From: michael wood [REDACTED]
Sent: 02 December 2020 09:40
To: Julie Grieves <Julie.Grieves@arun.gov.uk>
Subject: Re: BN/139/20/PL - The Cottage

The ground floor area has a total NIA of 88m² / 102.1m² footprint which is the combination of the retained element of the existing garage (15m² / 16.6m²) and the new build element of the proposed dwelling (73m² / 85.5m²).

GROUND FLOOR PLAN
1:50

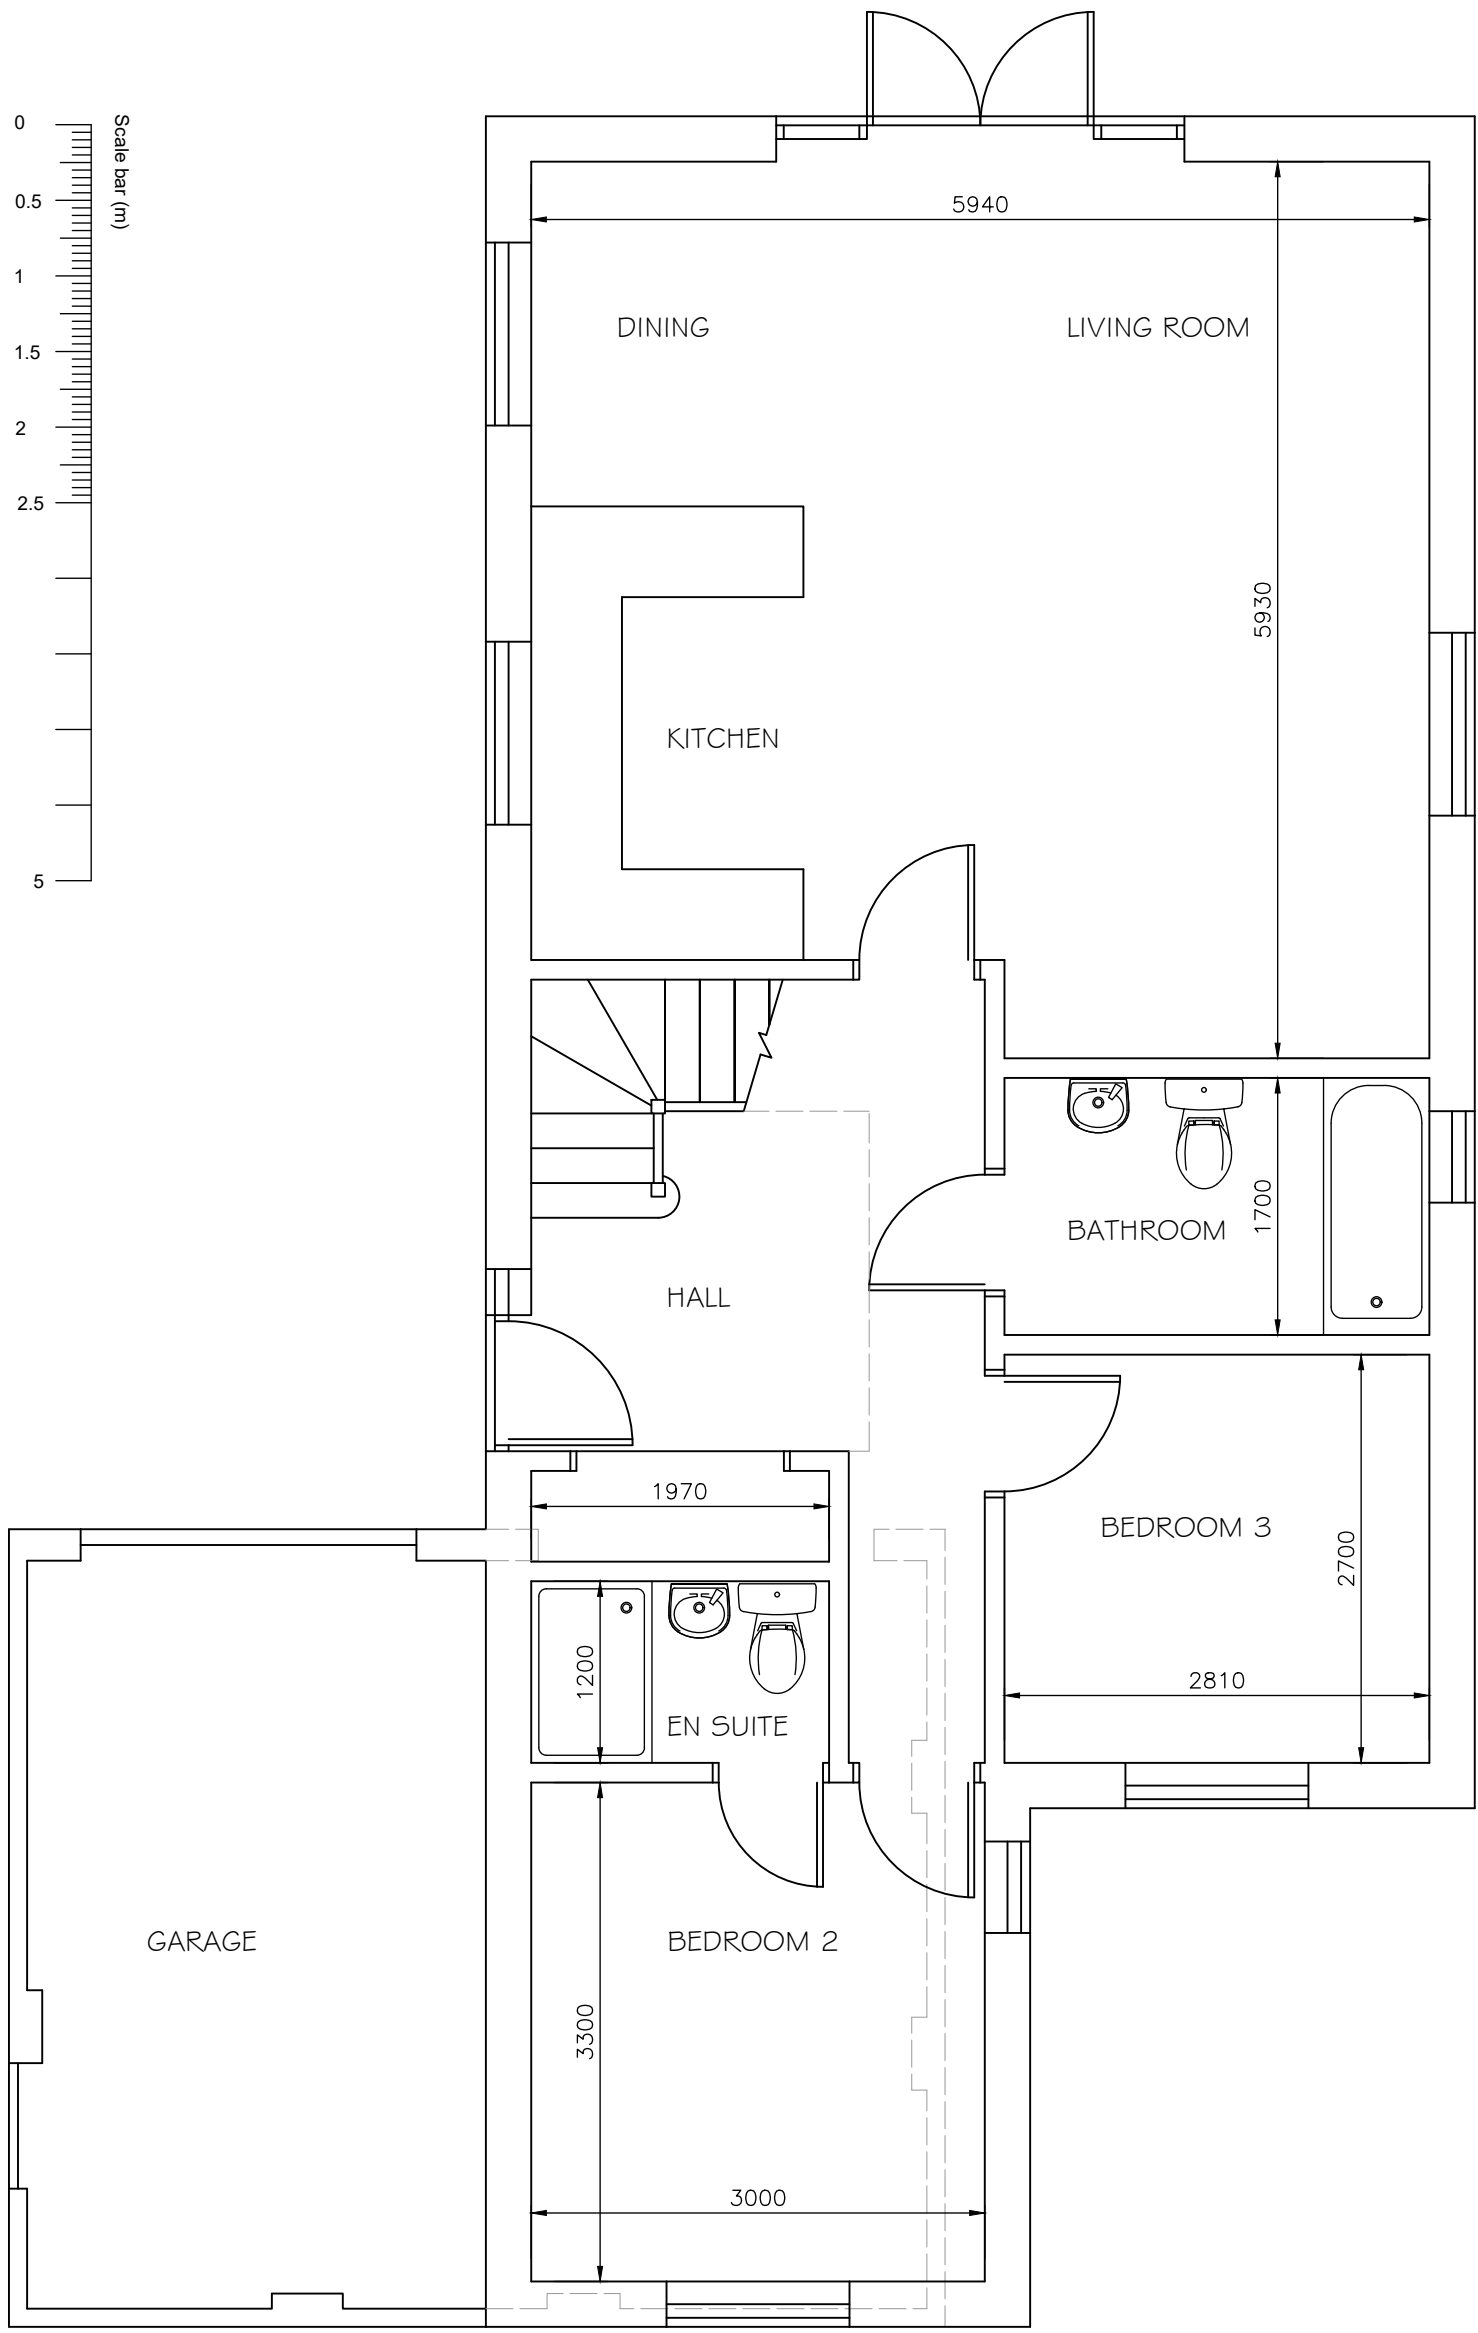
Does the new ground floor area include the proposed new garage?

The case officer has contacted me to advise that he has double checked floor area on this application. This is done, just to double check the floor areas that are on the CIL Form 1 Additional Information forms. Mr Davies has measured and calculated a floor area of 139m² with the proposed double garage. Are you also demolishing an existing garage? If so, you must provide proof of 'in lawful use' so utility bills ie council tax bill, heating bills etc is acceptable

Can you confirm you agree with the revised measurements and confirm the garage measurement.

I will check the CIL form however my checking of the floor areas is as follows and it is assumed that the existing garage will be part retained and part demolished.

I had taken net internal floor areas rather than the footprint of the building which may account for the differences.

Existing garage NIA - 29.4m² / Footprint - 32.7m²

Retained garage element NIA - 15m² / Footprint - 16.6m²

Proposed GF new dwelling NIA - 73m² / Footprint - 85.5m²

Proposed FF new dwelling NIA - 35m² (not including attic space of 9m²) / Footprint 38.6m²

Therefore the net increase is NIA 108m² / Footprint - 124.1m².
